Recommendation: Refusal

Applicant: Cornerstone Place

Proposal: Change of use to 18 x 1-bedroom flats (Class C3)

DRAWING:
BLOCK PLAN

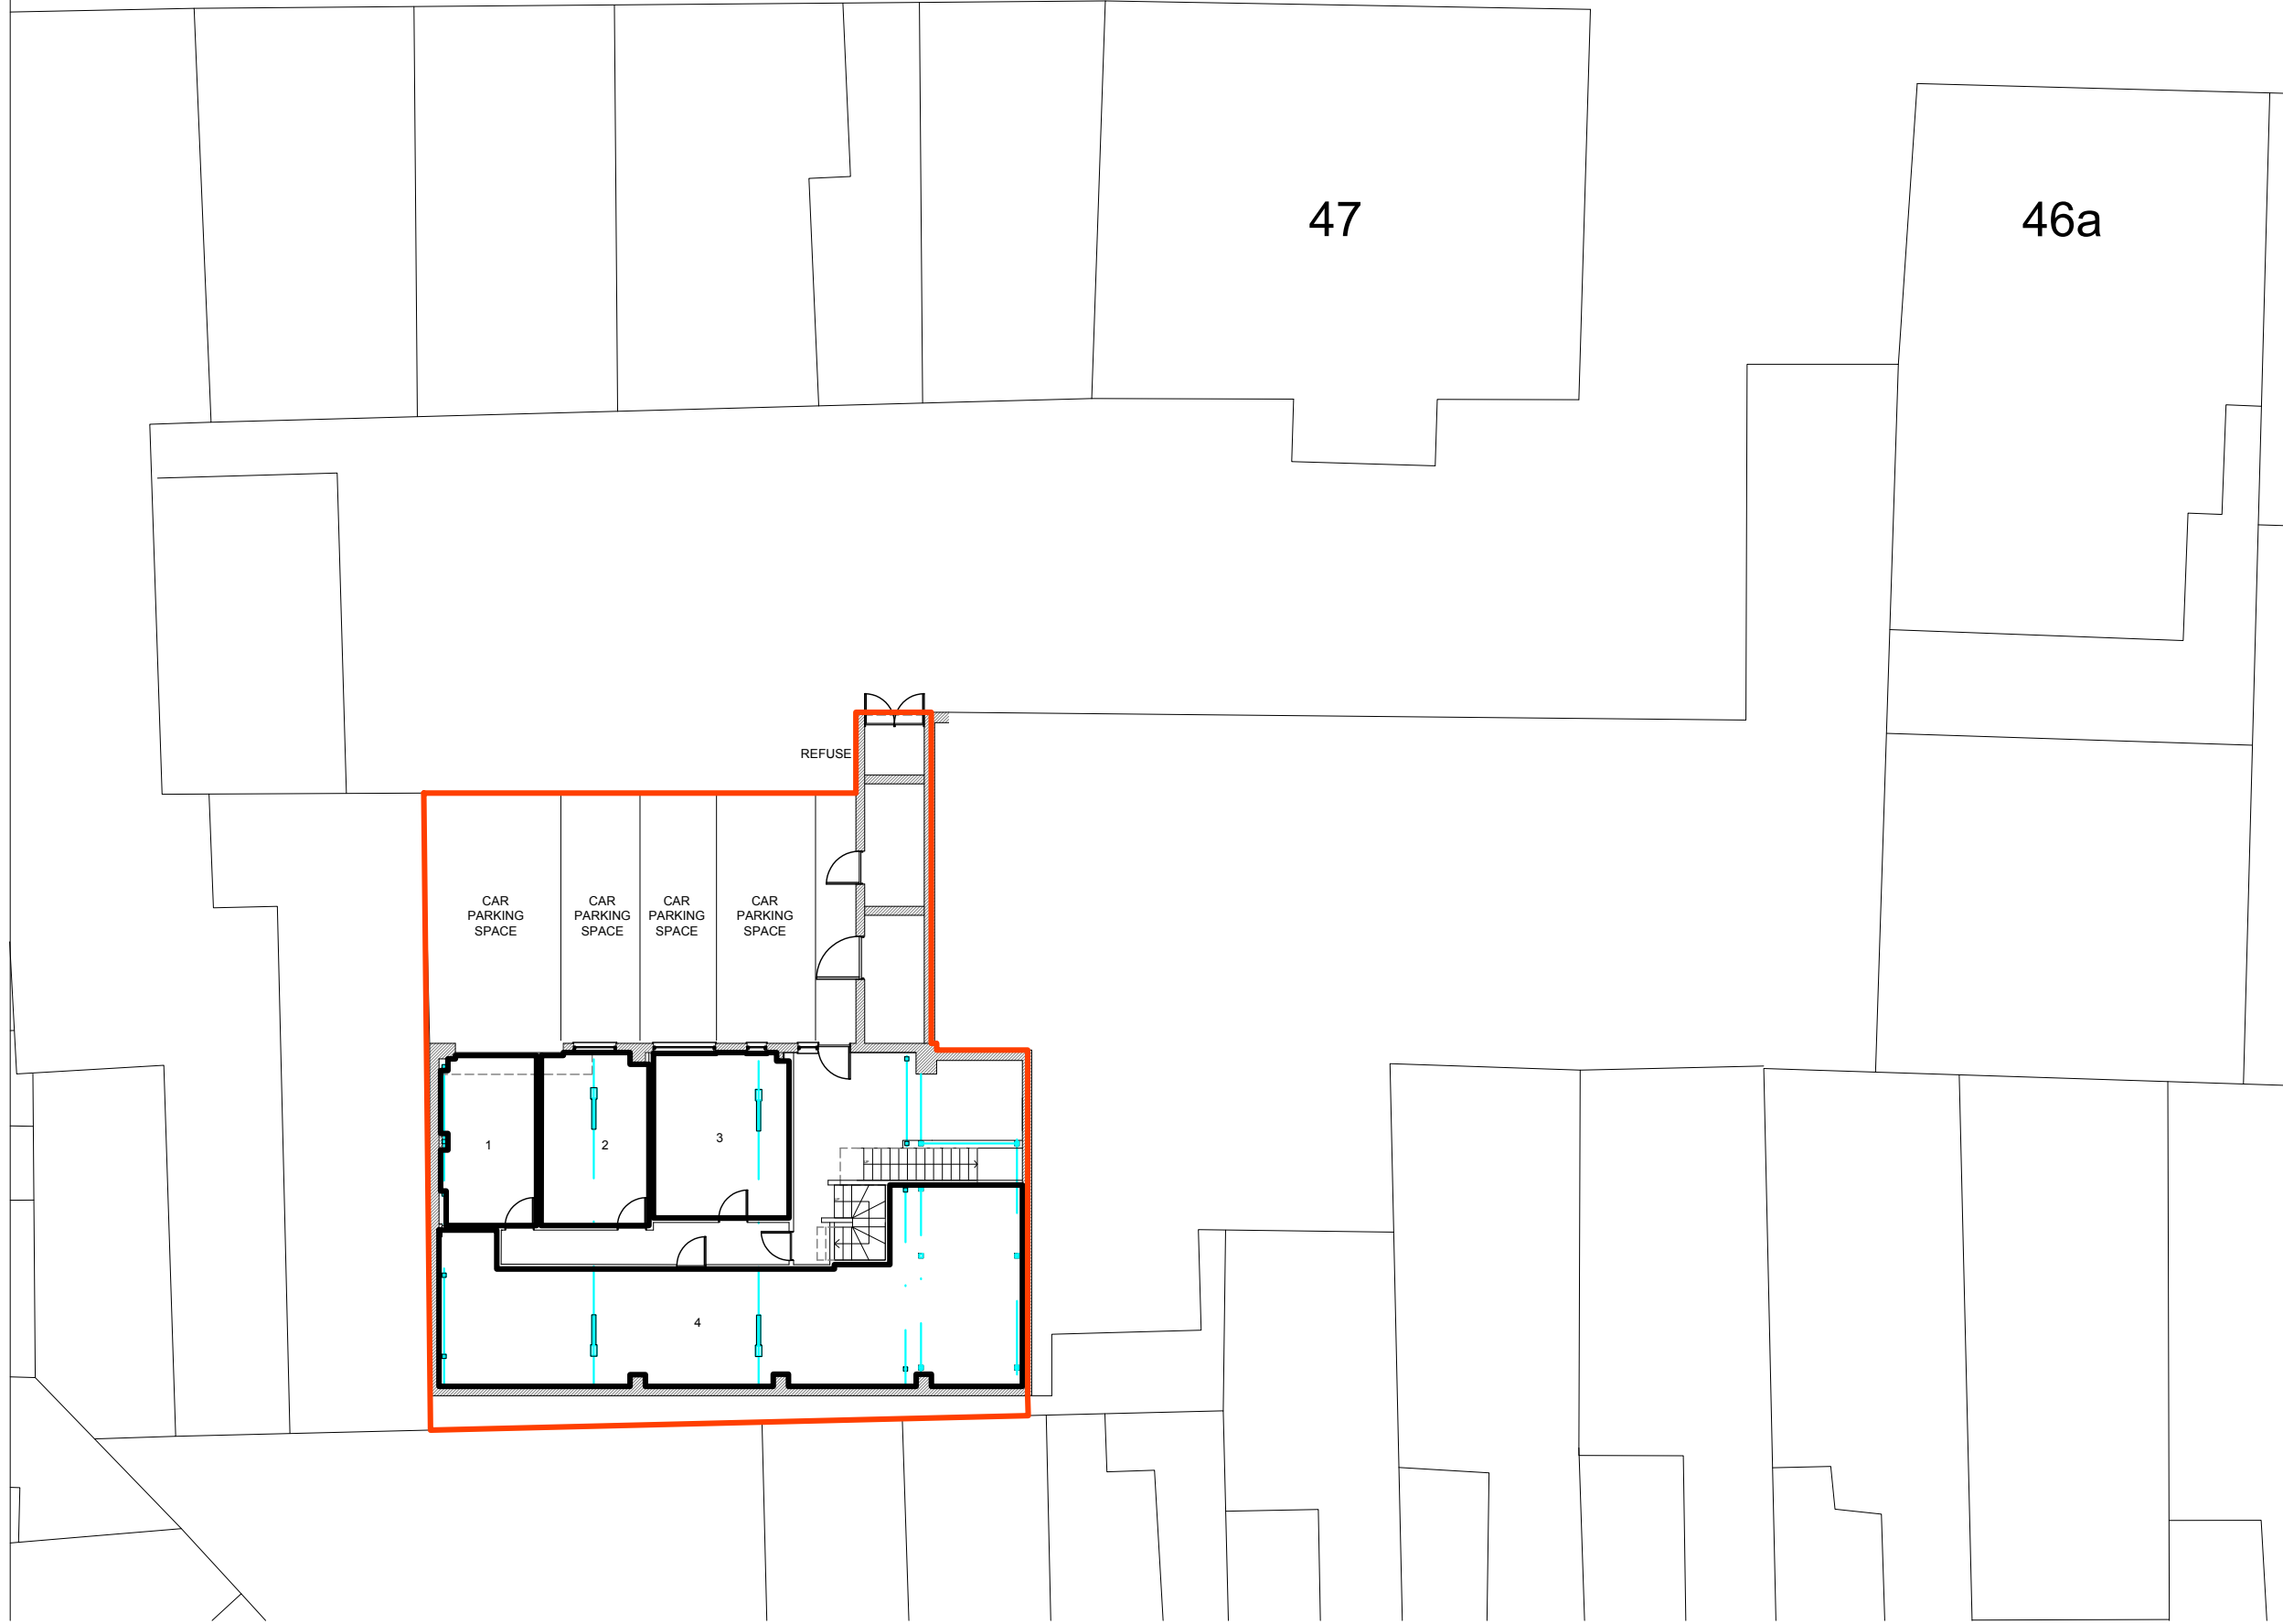
**Whilst the applicants contend that the gross floor space of the building is 483m² from measurement of the submitted plans officers consider the gross floor space of the existing building to be in excess of 500m² at 562m² (G.E.A.).
The proposal thereby fails to accord with this criterion.**

- 8.16. The PPG (Paragraph: 024 Reference ID: 14-024-20140306) sets out in the requirements for applications that the application site should be edged clearly with a red line on the location plan. It should include all land necessary to carry out the proposed development (e.g. land required for access to the site from a public highway, visibility splays, landscaping, car parking and open areas around buildings). Whilst the applicants have provided evidence of rights of access during without the access being included within the application's site boundary such matters cannot be considered; if the application were to be approved on the basis of the submitted red line plan, the site would be marooned without a vehicular access, meaning that, notwithstanding the limited parking provision proposed, vehicles from the development would need to park outside of the site potentially leading to an increase in demand for on-street parking within Broad Street.

- 8.17. Whilst four parking spaces are proposed (indicated by the applicants to be allocated to individual units) this would be below the usual requirement for a development of 18 no. 1-bed. However, it is considered that due to the site's relatively sustainable location within the town centre with good access to the services and facilities that the town centre has to offer, including public transport options, parking requirements could be reduced in such circumstances. The LHA advises that if proposals are to be considered on the basis of car-free development that minimum standards for cycle storage would have to be met for the proposals to be considered acceptable; which in this case would be for a requirement for 27 spaces including provision for visitors.

- 8.18. The proposals do not show any cycle parking within the submission and officers consider it unlikely that appropriate provision could be made without it impacting either on the number of units proposed or the size/layout of such as submitted.

- 8.19. During the case officer's site visit it was noted that on-street parking in the area was very much in demand within the vicinity of the site, with some instances of inappropriate parking, breaching parking restrictions in the area. The site itself was also quite congested with a number of vehicles parked at the rear of commercial properties to the east of the site fronting onto Broad Street, and parking within the area reserved for manoeuvring within the service yard area. There is no existing dedicated pedestrian access route and given the constrained nature of the site it is unlikely that such could be achieved. This would lead to conflict between pedestrian and vehicle movements and therefore to the detriment of highway safety.
